City of Albuquerque Stormwater Construction Site Inspection Report

ESC File No.	A11E017_Omni	Project Name:	Omni Universal Trust Lots 8 & 9 Unser/McMahon		
NPDES Id. No.		Location:	5762 McMahon Blvd NW		
2/16/2023	Owner	Contractor			
Operator	Omni Universal Trust				
Contact name & title	Michael G Rosenberg trustee				
e-mail	mgr@lobo.net				
Contact Phone #	970-259-7501				
COA Inspector	Doug Hughes	Start/End Time:	8AM		
Construction Phase:	Lots 8 & 9 Graded with subdivision (CGP ID# NMR1004PN)				
Type of Inspection:	Regular	Storm Event	Post Storm Event >0.25"	311/Complaint Follow Up	
Weather at time of inspection?	Clear		Temperature: ~	20	
Estimated date of last storm 0.25" or greater	12/4/2022

# ECP (LOTS 8 AND 9 -LOD - SHOWN IN BLUE BELOW)

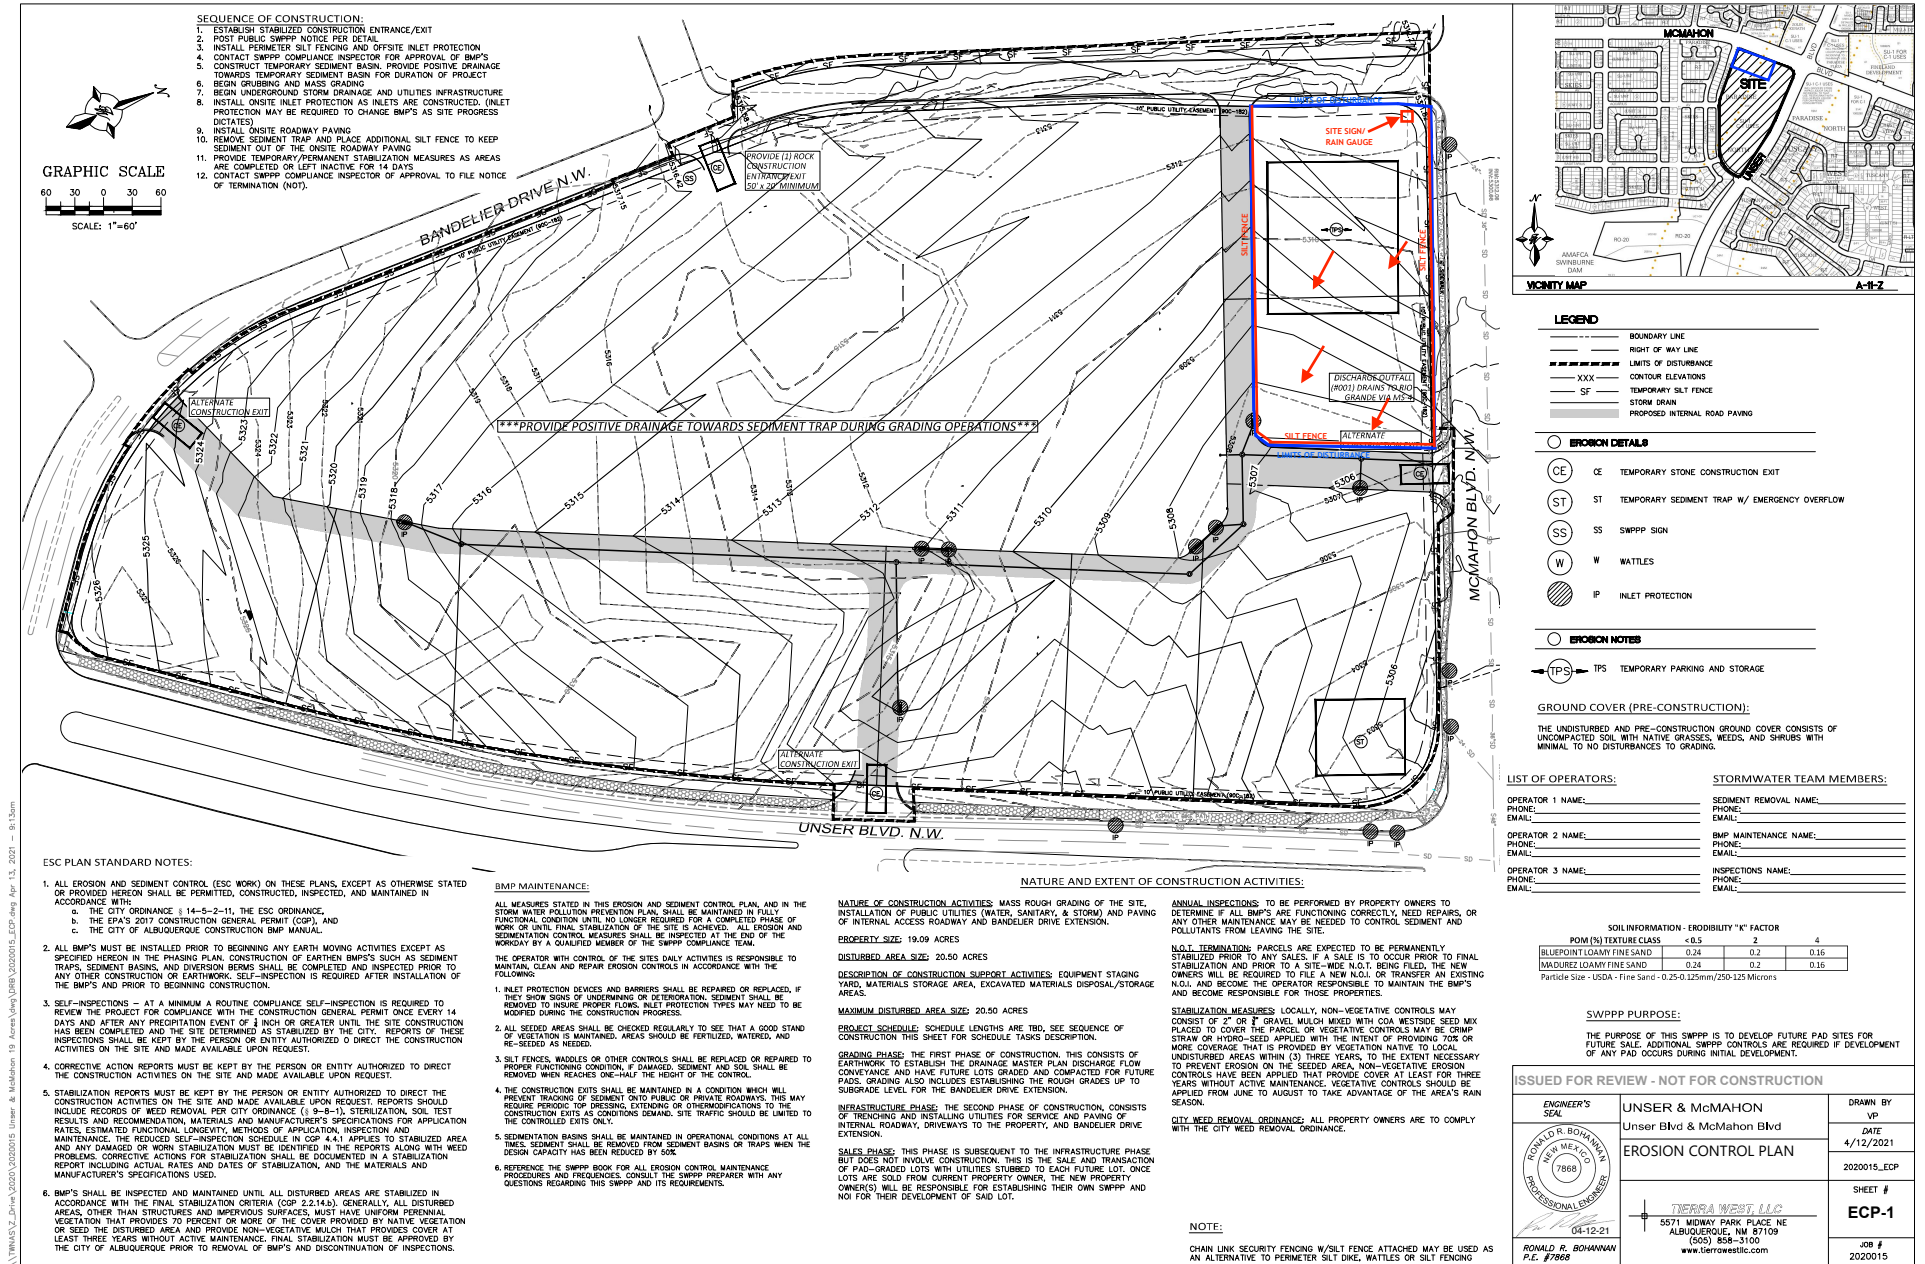
Item Number	Deficiency/ Corrective Action				
1	Stabilization not complete, mostly bare dirt and weeds.				
2	NOI hasn't been submitted to the City for approval				
3	CGP coverage isn't posted on a sign for safe public viewing				
4	SWPPP not available on site				
5	Perimeter BMPs are incomplete				
6					
7
